Your Ref: OWPC17735
Our Ref: CM/3/18/HH 18-02-2018
Please ask for:
Mark Jones

Raising of first floor to utilise attic space.
Atherington Lodge Climping Street Climping

Proposed Roof Plan

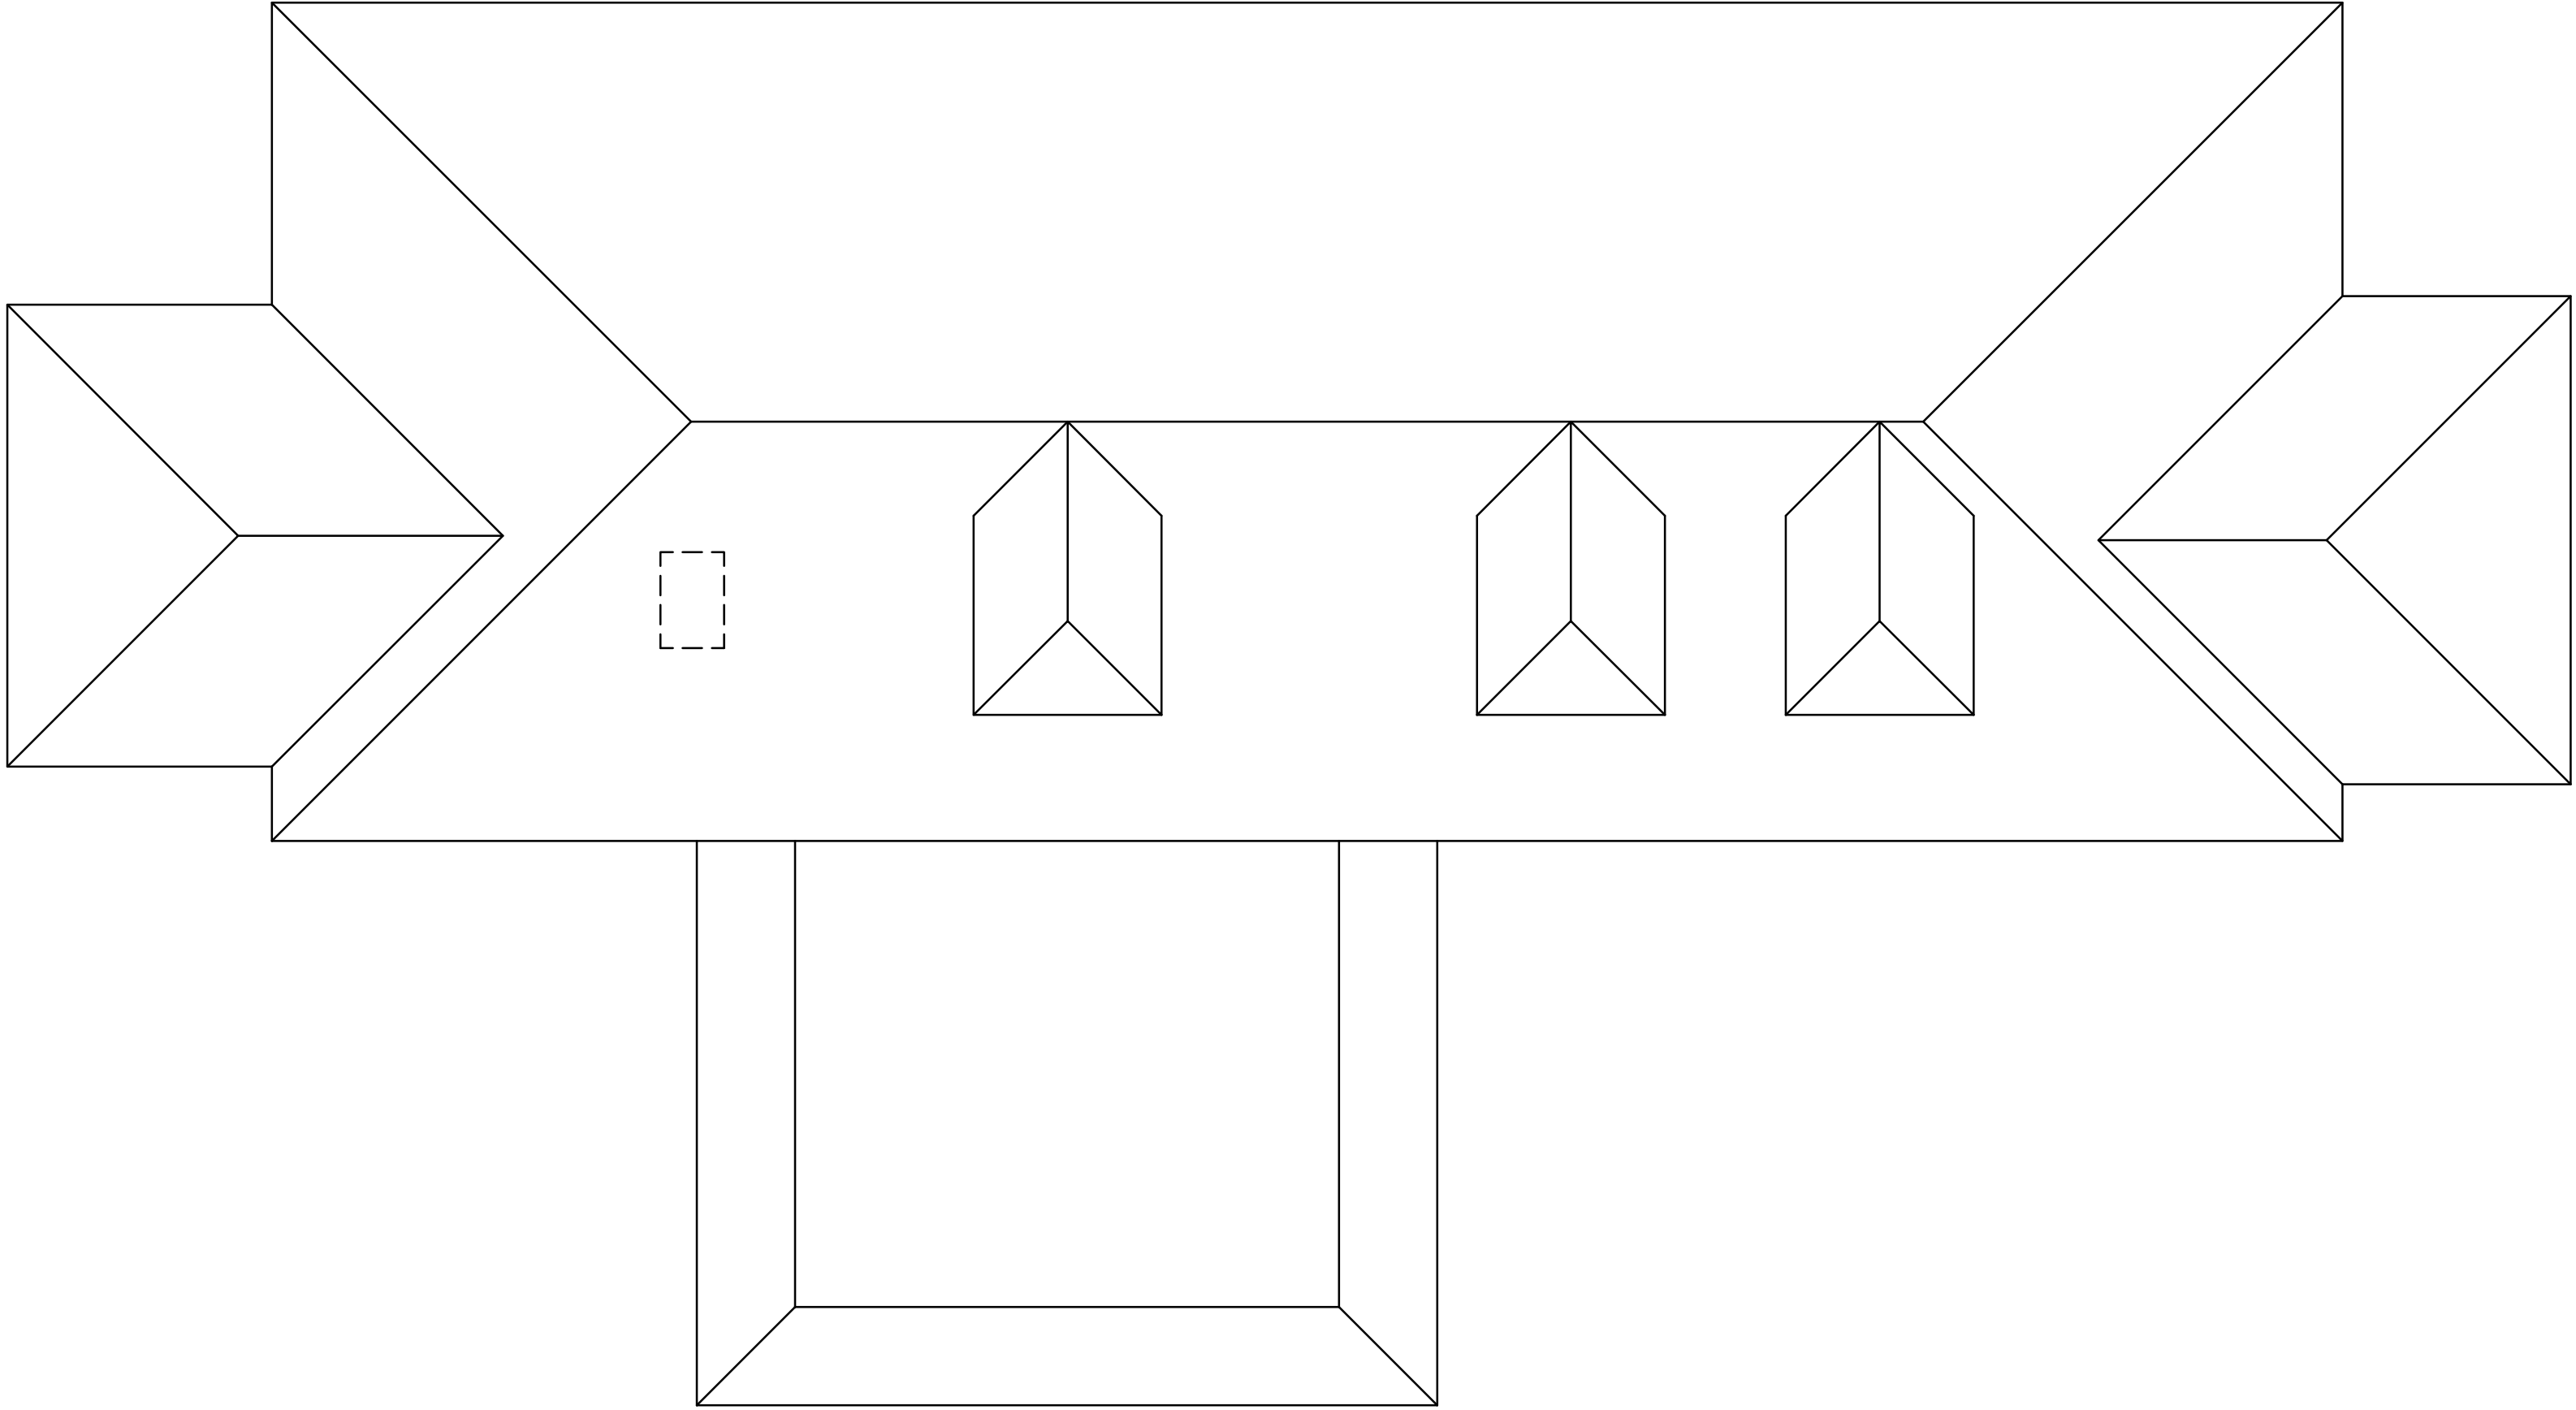
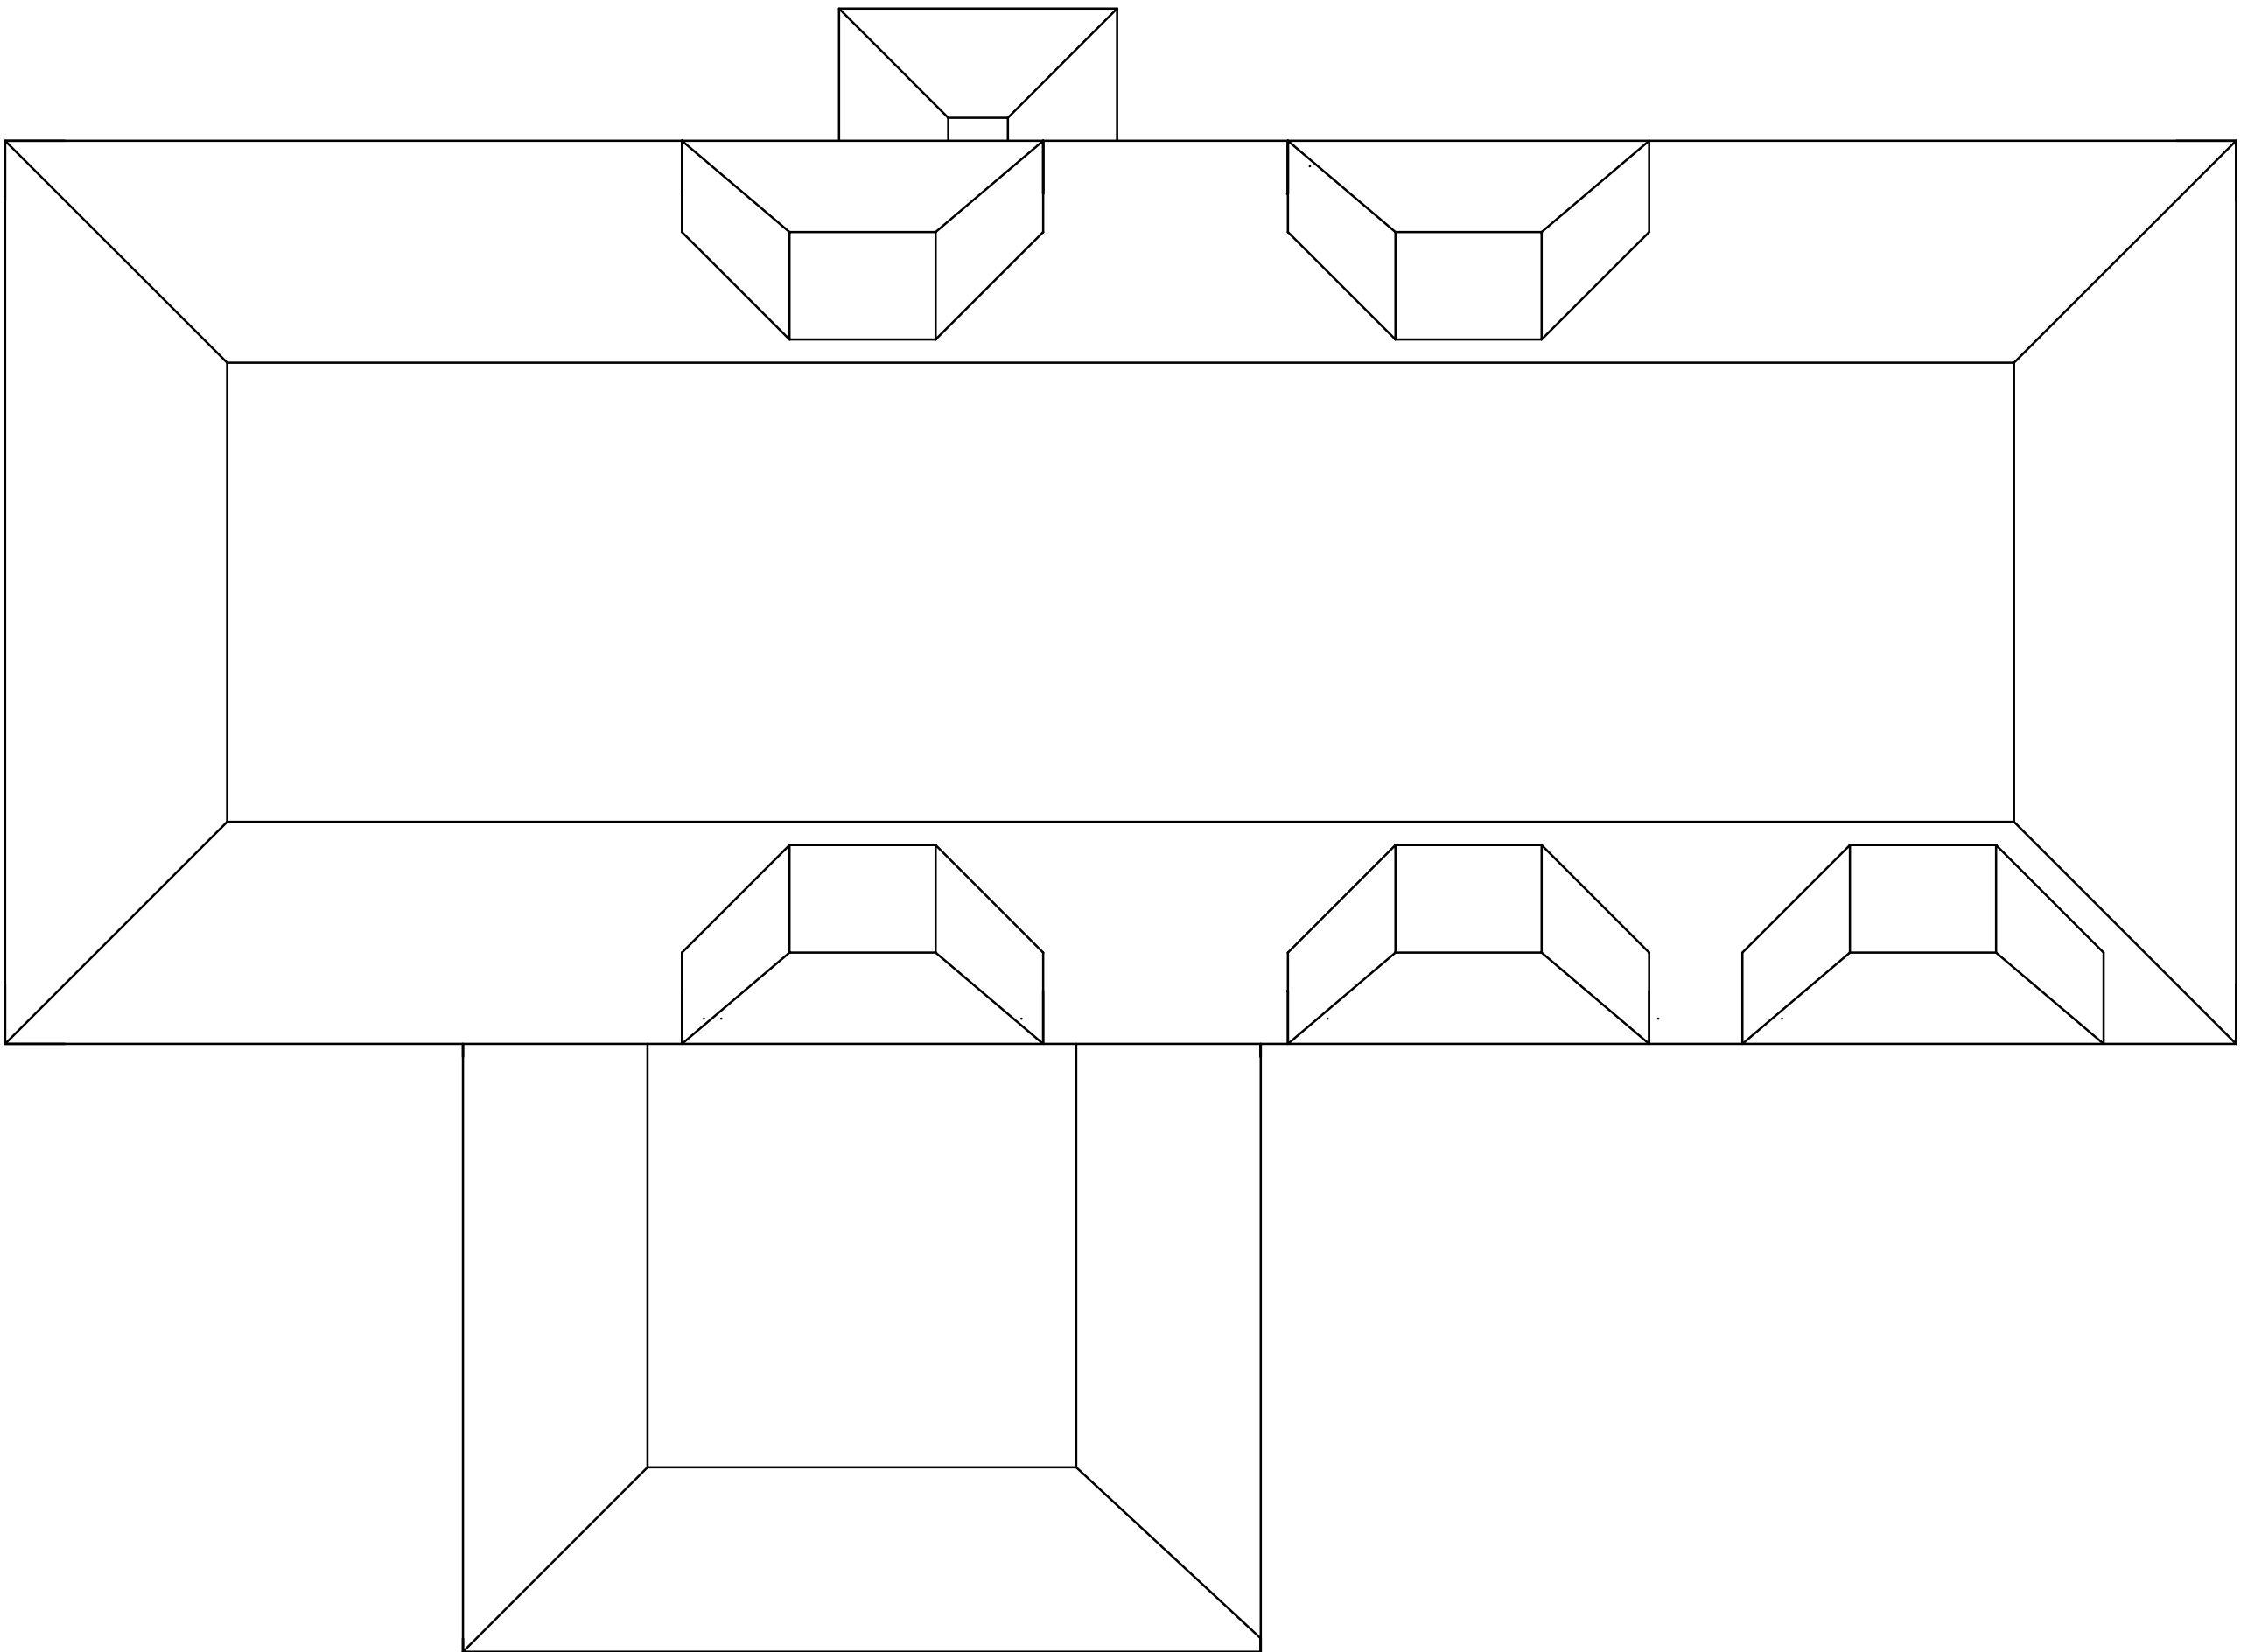
My only concern is the addition of 2 new windows on the west side of the roof where currently there are none. These 2 windows will look west, towards my property, rear garden, patio area and directly at the windows of the main bedroom. Given that the Lounge and Kitchen are to be relocated upstairs, overlooking is more likely to happen as these rooms will be used during daylight hours than if these were to remain as bedrooms. At Climping Parish Council's meeting on 27.03.2018 Councillor Adler commented that there is likely to be overlooking from these 2 windows, but that she would leave it to the householder to raise as an objection. If these 2 windows are to remain, would it be possible for the glass to be opaque to allow light into the property but not views out of it ?
kind regards, Alison Baird
